CITY OF ALBUQUERQUE
MUNICIPAL DEVELOPMENT DEPARTMENT
ENGINEERING DIVISION/DESIGN HYDROLOGY SECTION

CONFERENCE RECAP

RE: DRAINAGE PLAN FOR CARLISLE RETAIL CENTER
RECEIVED DECEMBER 19, 1985 (H-17/D39)

RE: DRAINAGE PLAN FOR CARLISLE RETAIL CENTER
RECEIVED JANUARY 17, 1986 (H-17/D39)

TITLE: ALLEY GRADES BETWEEN LOS ARBOLES RD. AND CLAREMONT AVE. N.E. - BEL-AIR SUBDIVISION

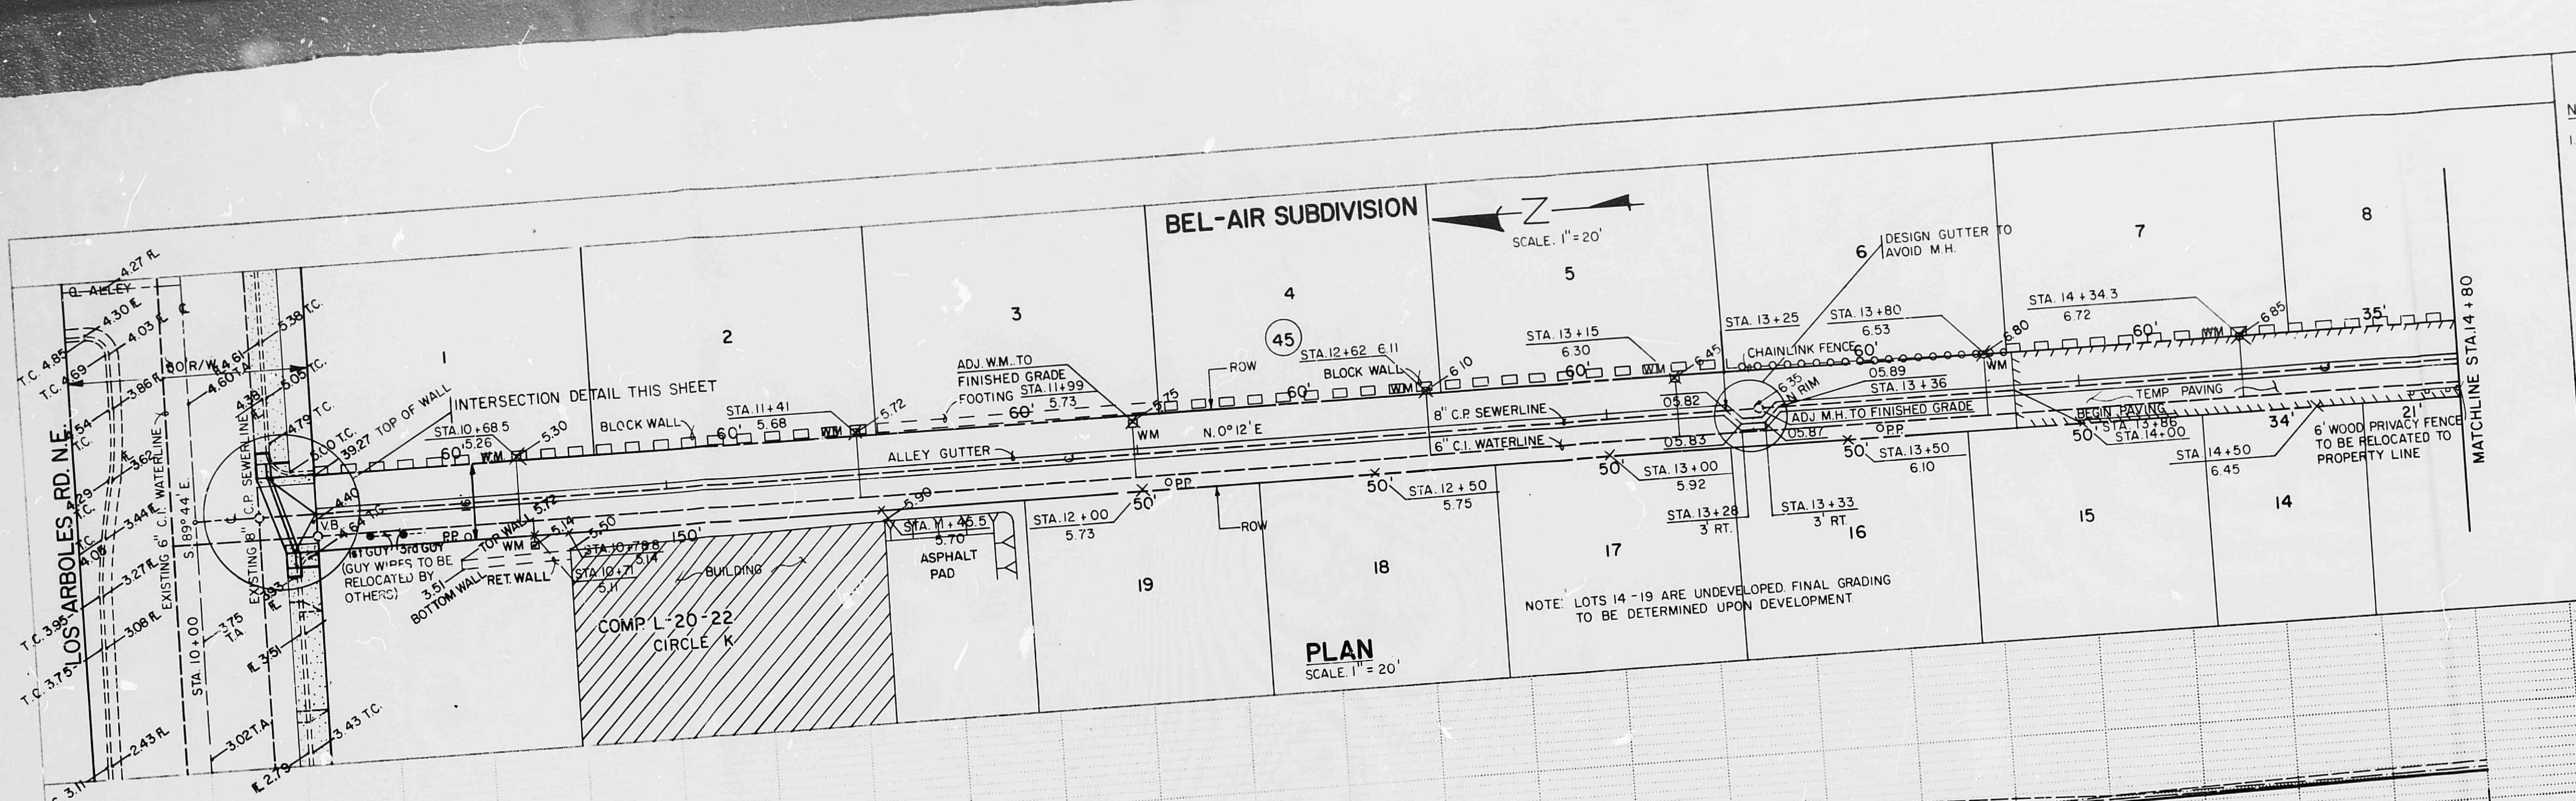
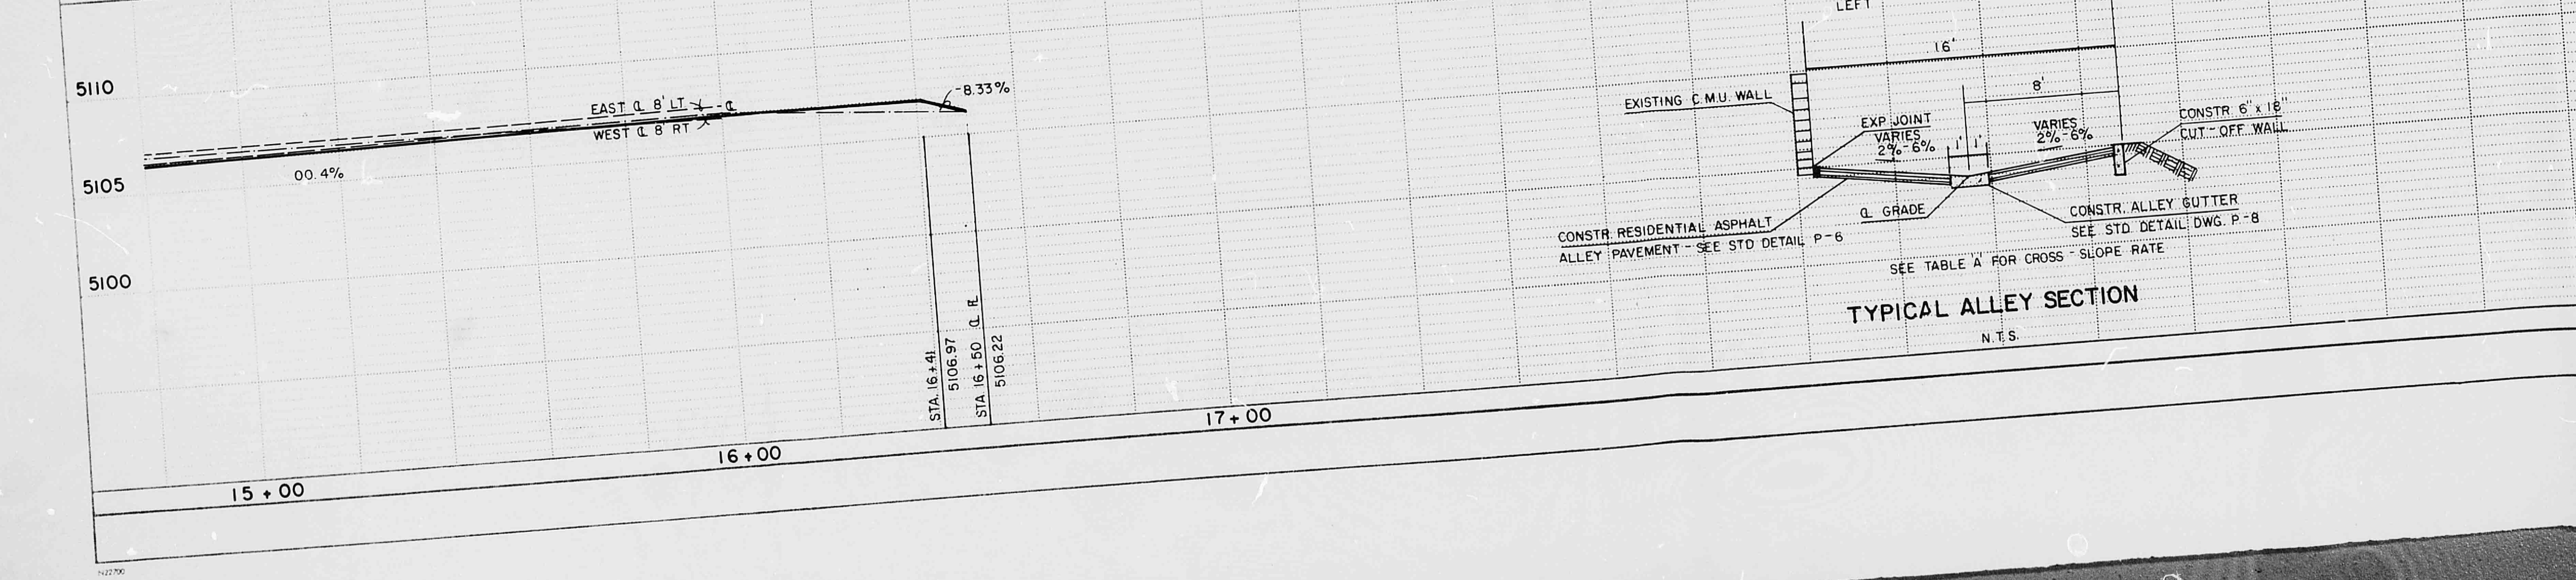
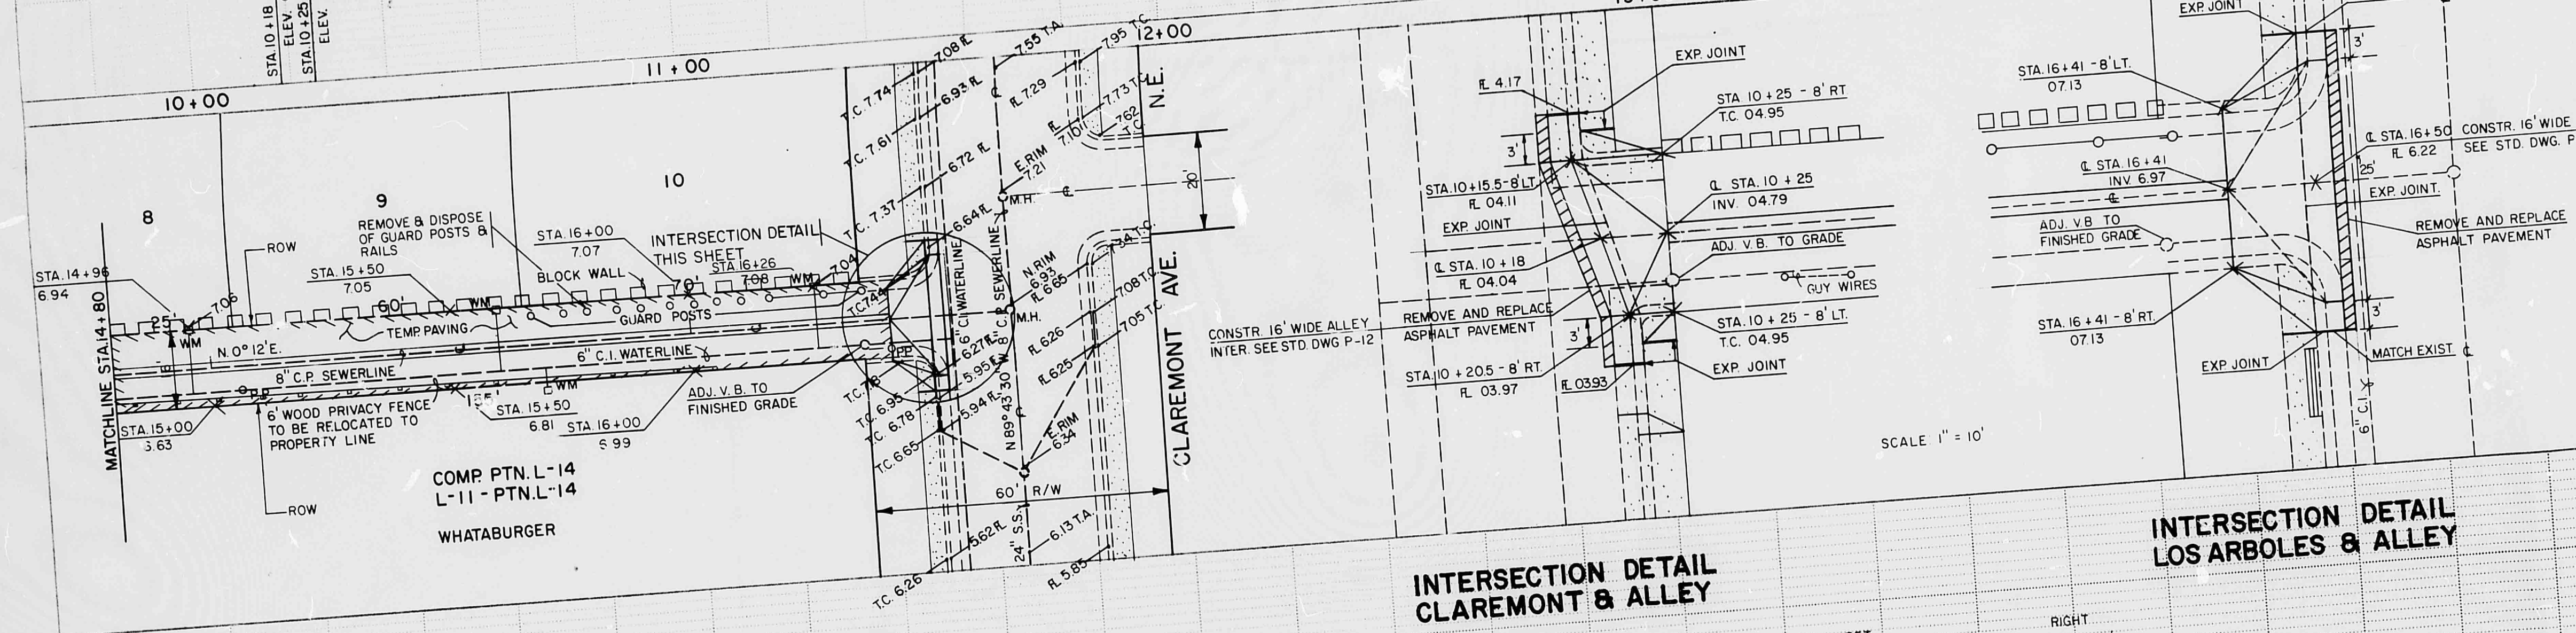
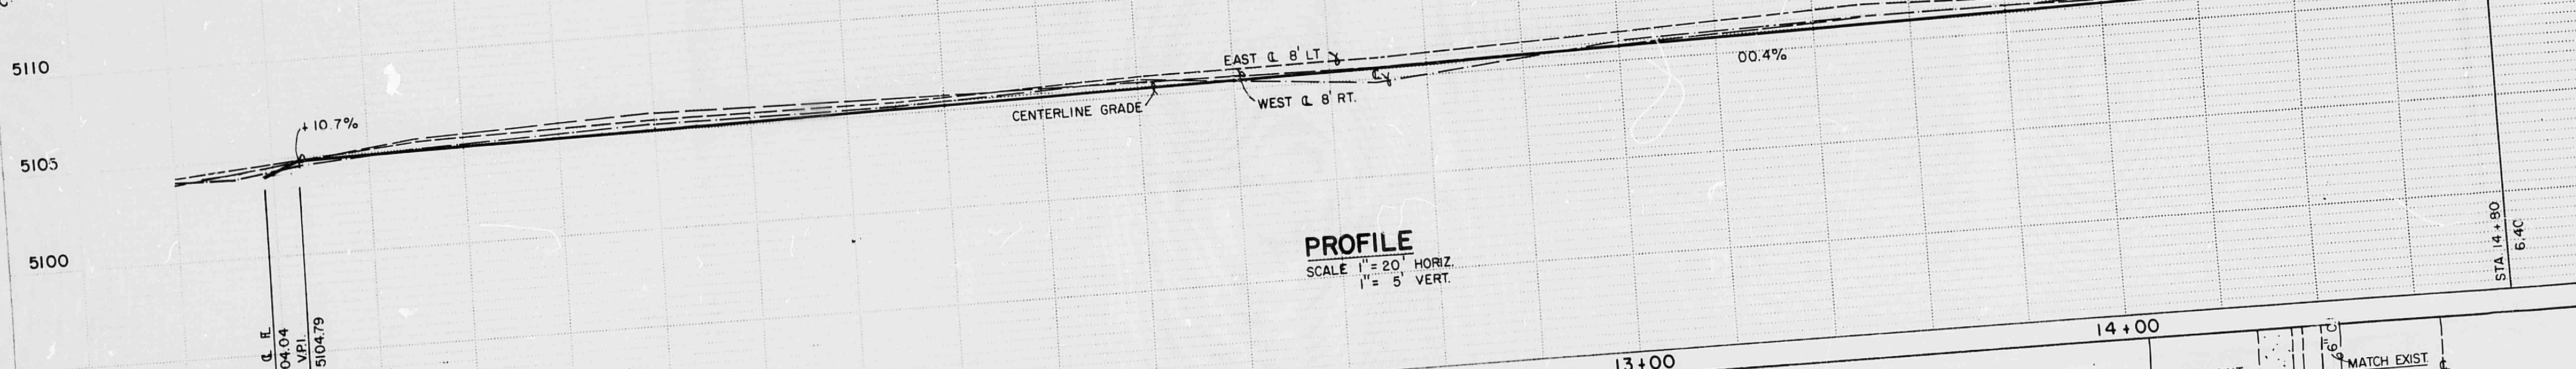
- ① Discharge to be determined by analysis of downstream capacity
- ② City approved alley grades are required for the existing unimproved alley. These grades are required prior to issuance of the C.D.
- ③ An approved erosion control plan is required for the period of construction to ensure that sediments remain on-site.

GRADING AND DRAINAGE PLAN LOTS 16, 17, 18 & 19, BEL-AIR SUBDIVISION ALBUQUERQUE NEW MEXICO

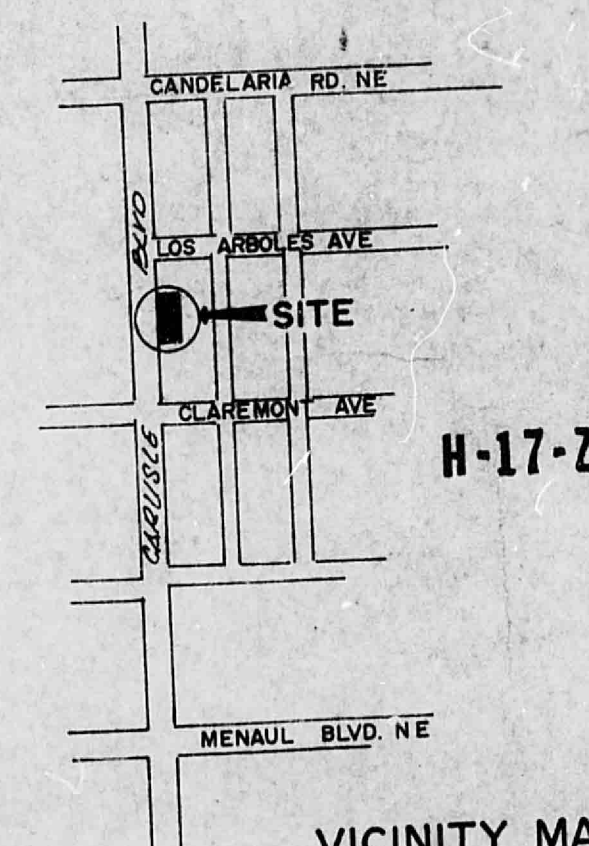
1. The site has not been identified with respect to flood hazard. Is the site in or out of a flood hazard area?
2. The verbage on the plan states that there is a separate submittal on this site. I fail to find the additional information, please provide an additional copy.
3. It was identified that City approved alley grades will be required ~~for building permit~~. I do not find any reference to this process undertaking.
4. The required spot elevations for the standard City drivepad have not been provided.
5. The contours as shown do not clearly indicate that the runoff will be contained onsite. It appears as if the runoff may discharge onto the property to the north.

How will the water be turned 90° as the arrow so indicates? The detail is lacking to confirm this scheme.

6. The property will need to be replatted to remove the lot lines or the appropriate legal documentation will need to be provided to allow discharge across these lot lines.
